Blacktown
City Council

Your ref: SSD 10477
File no MC-20-00007

SSD 10477 – Request for SEARs – Stage 3 Facilities Sydney Business Park, Marsden Park

Blacktown City Council submission to SSD 10477 – Stage 3 Facilities Sydney Business Park, Marsden Park

SYDNEY BUSINESS PARK - STAGE 3 - BUILDING 4
HOLLINSWORTH RD, MARSDEN PARK, SYDNEY

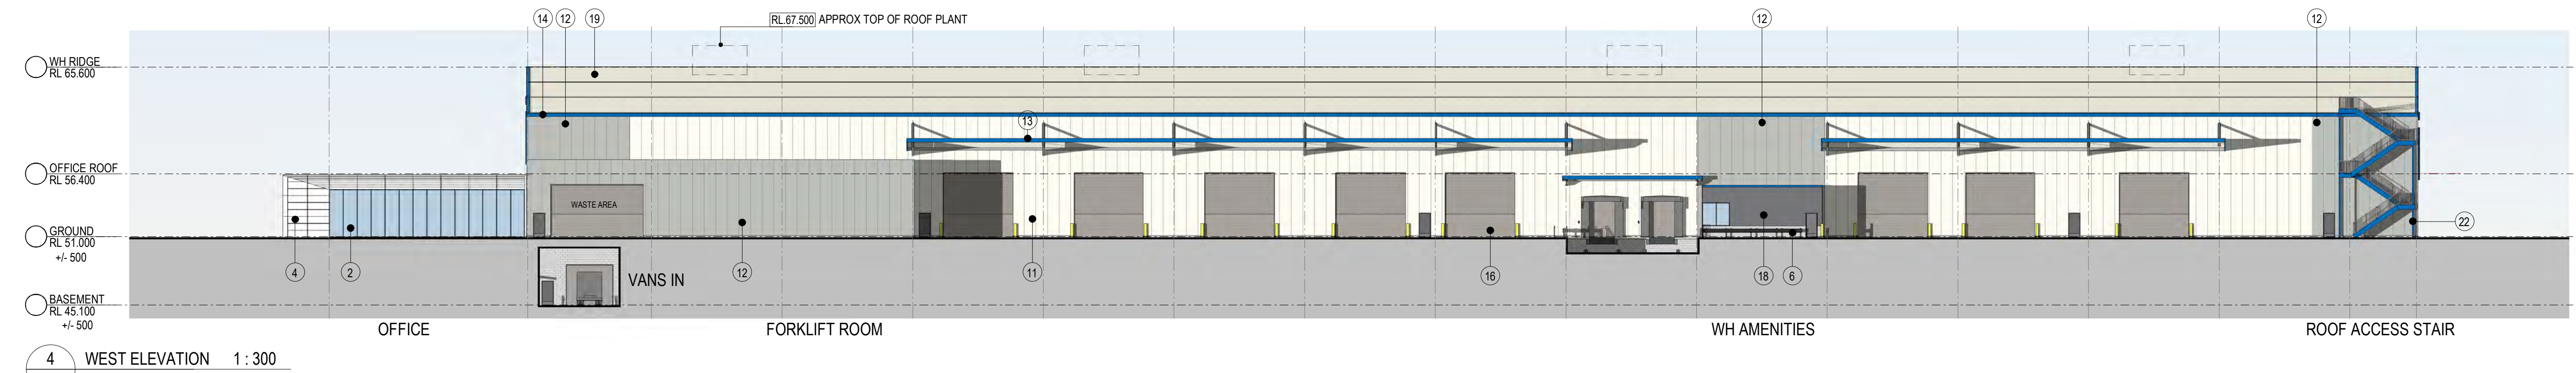
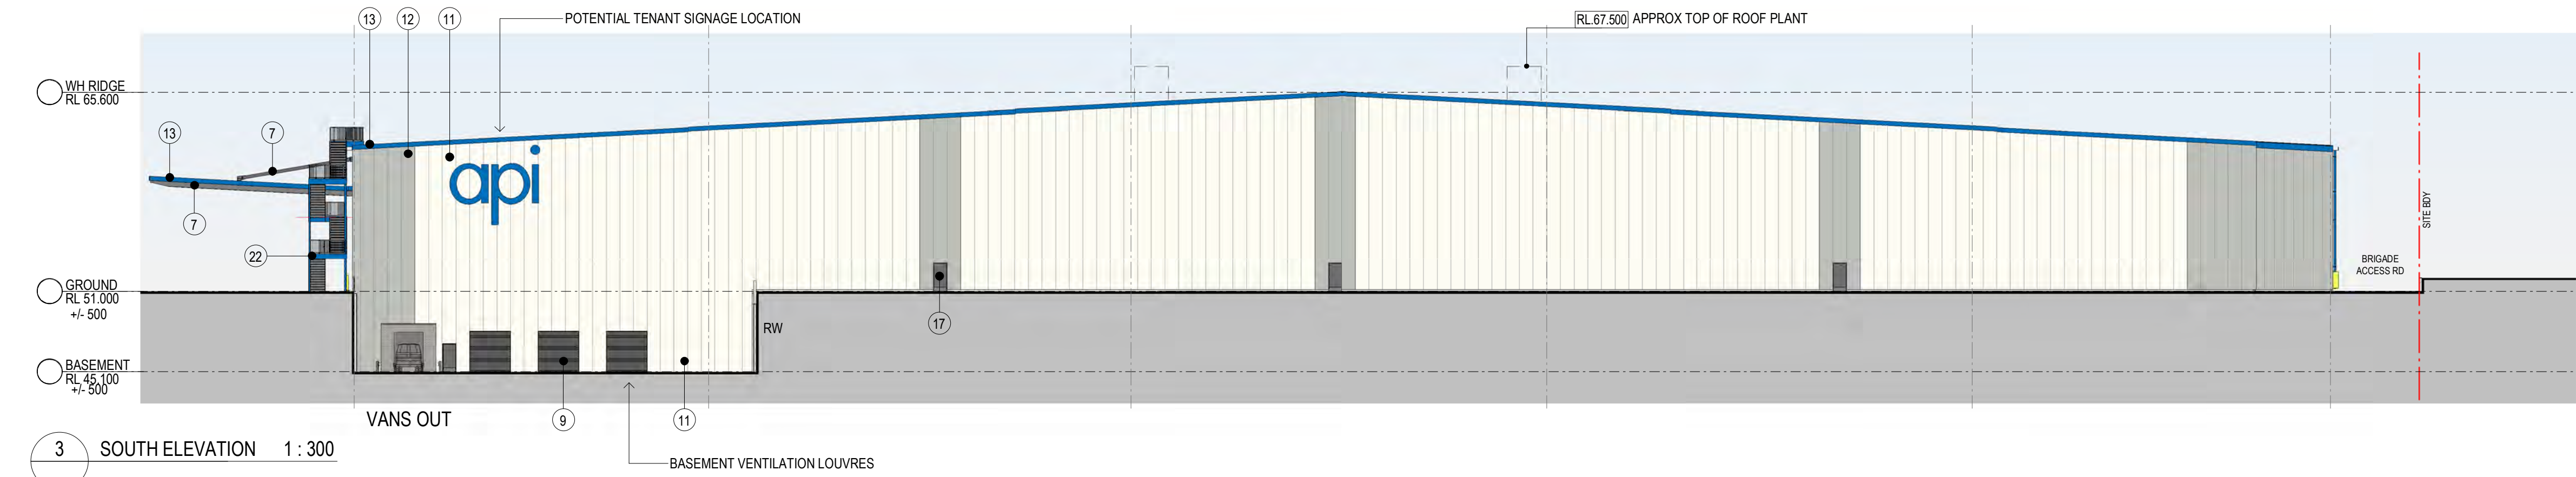
- g. The heavy vehicle driveway proposed to service Warehouse 4 is shown within the roundabout kerb line. In order for this to be considered by Council, a fourth southern leg of the roundabout must be proposed as a public road, with a transition to private driveway after a short distance. This is to ensure the vehicle movements within the roundabout are kept uniform and consistent to ensure road safety is prioritised for all directions of traffic.

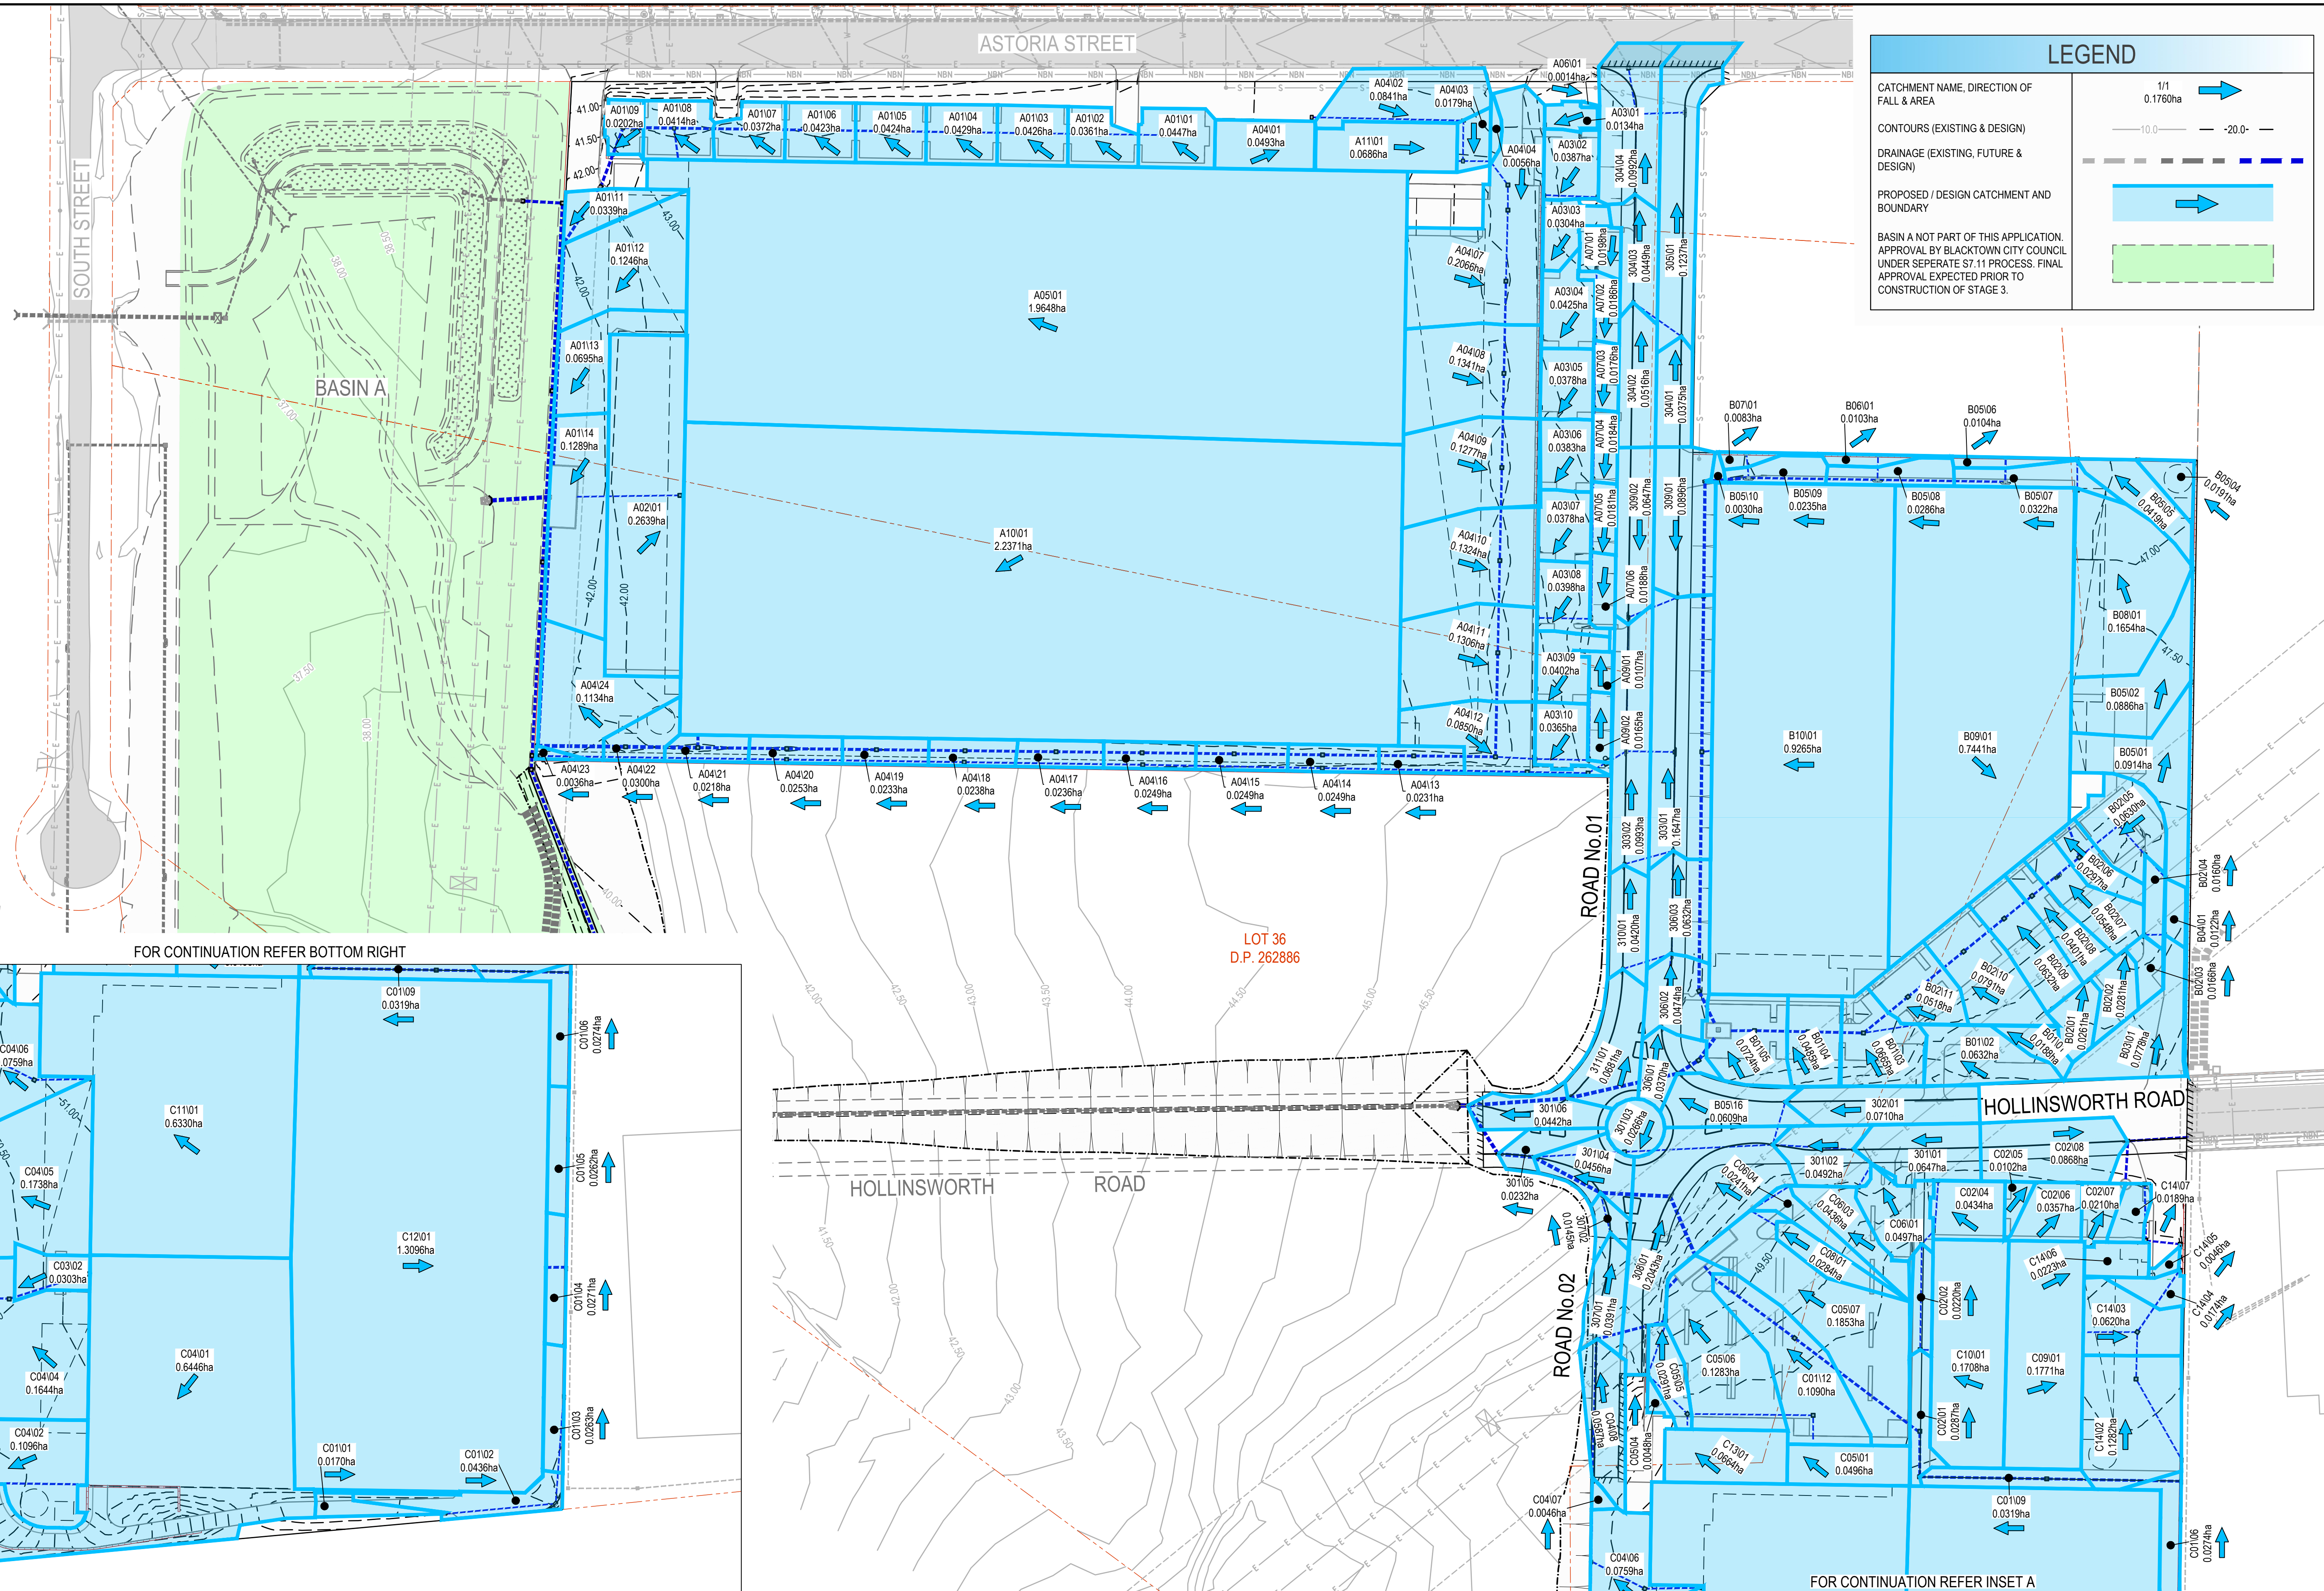
- c. All upstream catchments must be considered, and included on a complete catchment plan for Council's review. All upstream catchments must be captured and directed through the site, and discharged to an appropriate outlet location, ensuring no adverse impacts on adjoining sites.
